From: [Kathy Perkins](#)
To: [Kelly Bacon \(CD\)](#)
Subject: LP-22-0001 Suncadia Ph2 Div 7
Date: Monday, February 28, 2022 9:42:08 AM

RE: LP-22-0001 Suncadia Ph2 Div 7

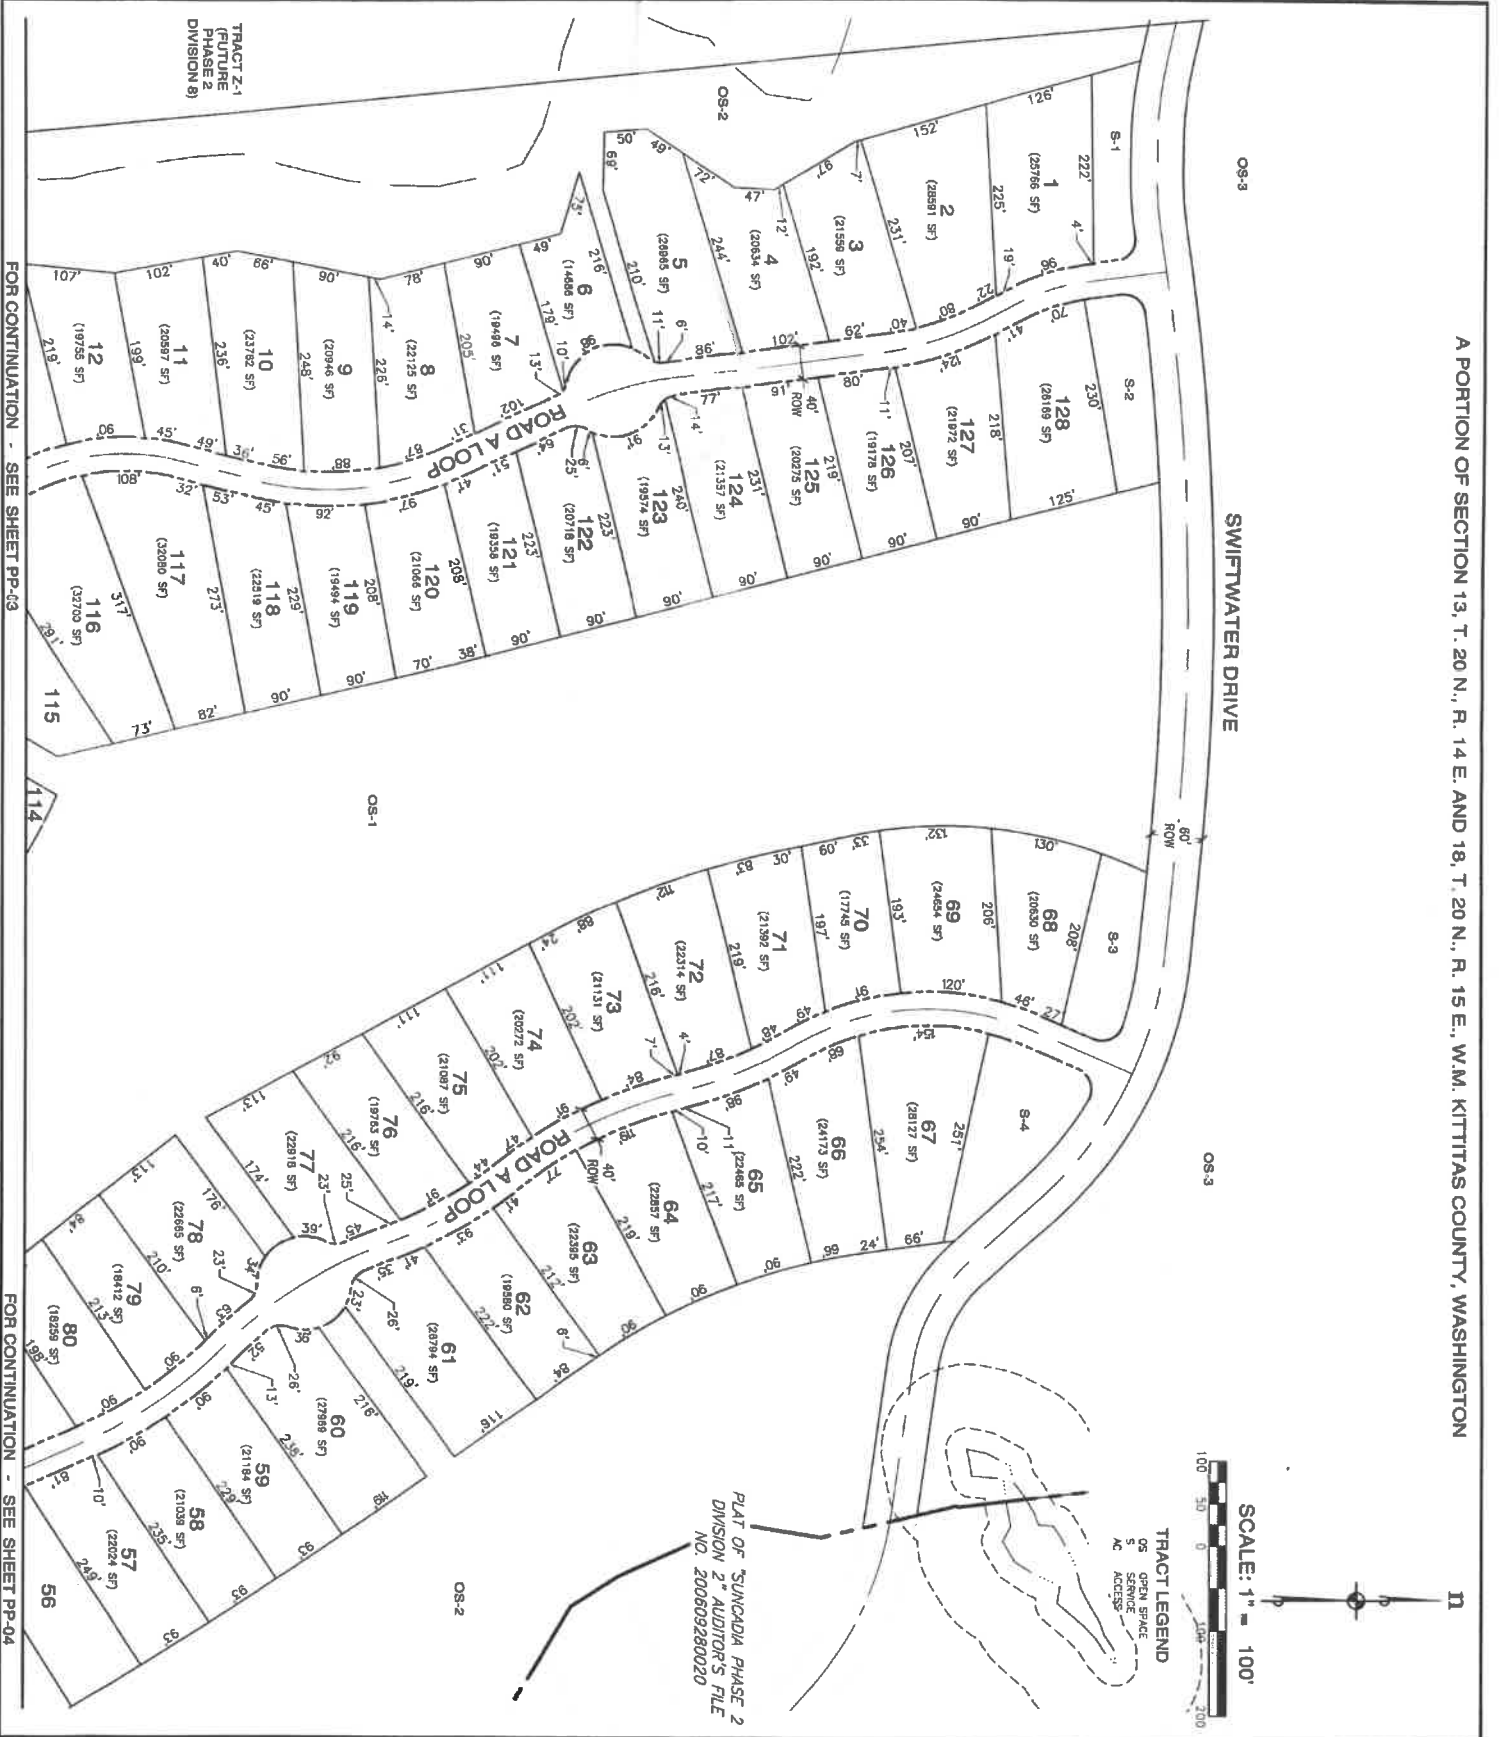
1. The placements of the eastern boundary lines of lot 67 to approximately lot 41. Under the current proposal, these lots back up to an elk corridor, a seasonal creek and seasonal wetlands. We live right above this area and each Spring; we see a seasonal stream and flooding near the proposed lot lines. We also see significant wildlife who use this corridor on almost a daily basis. My concern is that while I understand these lots will be developed, has there been any thought to how building next to the stream and where it floods will affect the water quality etc.? I have been lately been dismayed by the lack of regard for the environment that Suncadia has shown with some of their recent developments in Nelson Preserve such as the tract homes at the Cabins at the Farm. If you look closely at the Cabins at the Farm, you will see that some properties border on to a creek and there is already starting to be pollution and other things falling in the Creek during the development process. In the future, there will be pesticides, fertilizers etc. that will fall into the creek which flows into our drinking water as well. While it is too late to stop all the damage done from the Cabins at the Farm, it is not too late to make sure it does not happen again. For these reasons, I would encourage you to look closely at the lot lines on these lots and how close they are to the stream etc. It would be nice to push the boundary lines back to a point to avoid the destruction of the stream and limit the pollution. It would also help the area stay a wildlife corridor. The developers at Suncadia seem to have only one focus: to generate as much money as possible with no respect for the environment. I hope you will help get them on track of honoring their development agreement and protecting the environment. For these reasons, I ask that you do not approve this application without adjusting the boundary lines of lots 67 to approximately Lot 41 to take into account the seasonal stream and wetlands by pushing them back away from this area.

Site Development Plan Phase 2 Division 7

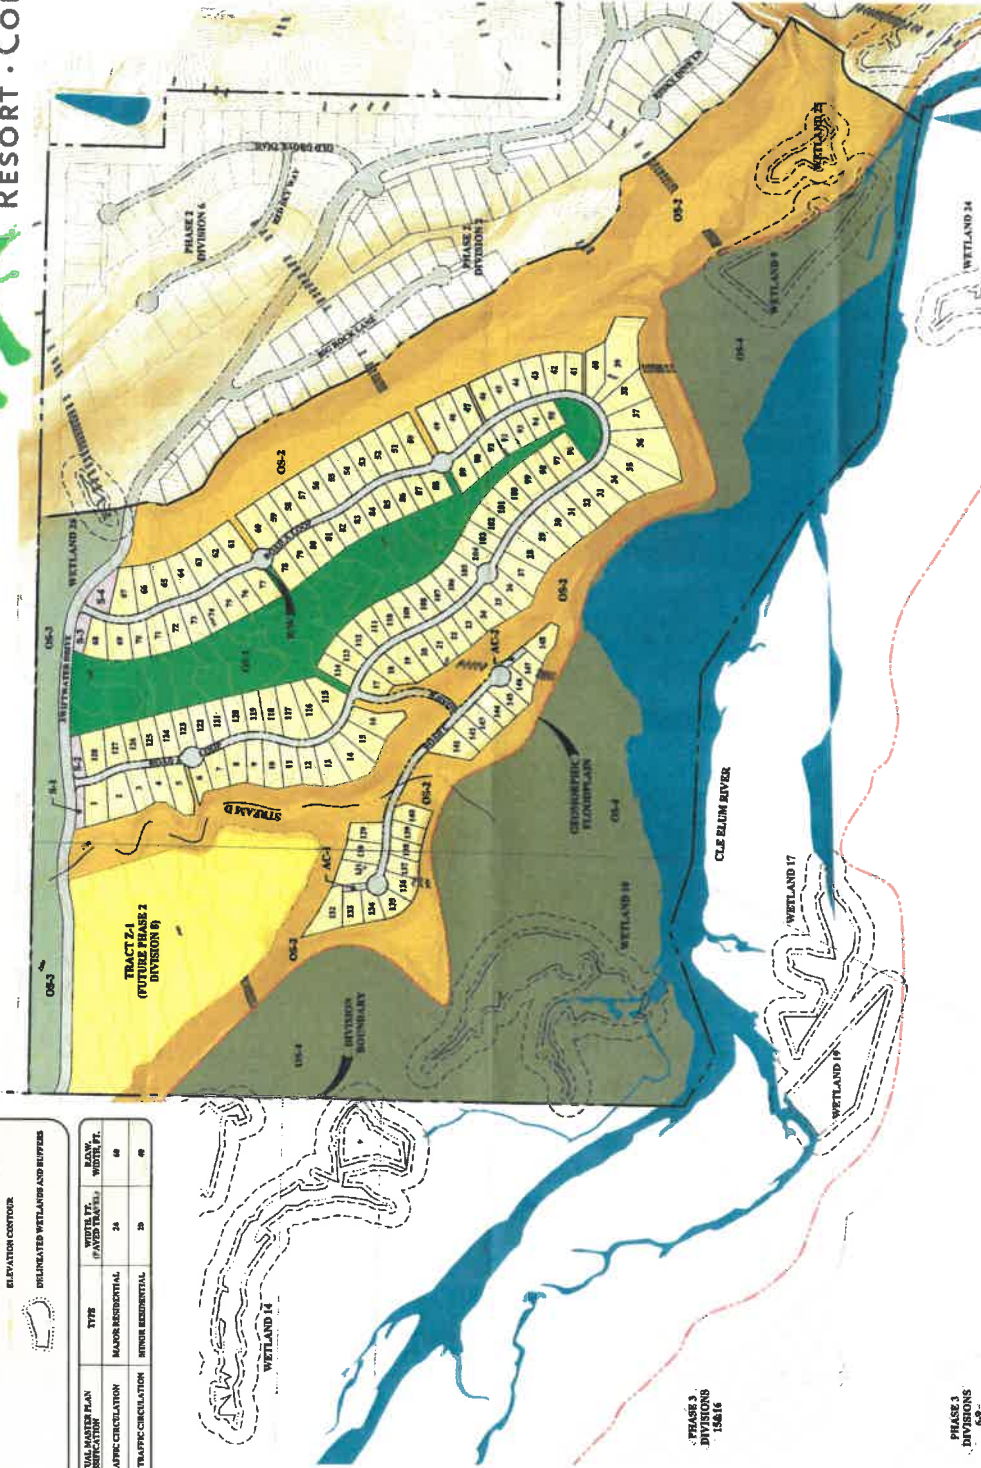
2. Safety concerns about one exit gate from Suncadia. Suncadia is just getting started on the development of hundreds of more lots in the Nelson Preserve. Yet, they are not planning any other exit route except the main entrance. I would like to ask there is in another entrance/exit for emergency purposes or a gate with a full-time gate guard. Suncadia simply cannot keep adding homes without an emergency exit route. I know they do "have" an exit off of 903 but in the case of emergency, will it work? Someone is going to drive down there and manually open it? There needs to be a better solution. Also, there will be hundreds more cars on Swiftwater now on a daily basis and this needs to be addressed with better infrastructure as well. For this reason, I am asking that you do not approve this application without having them add a second gate off 903 that is maintained 24 hours a day.
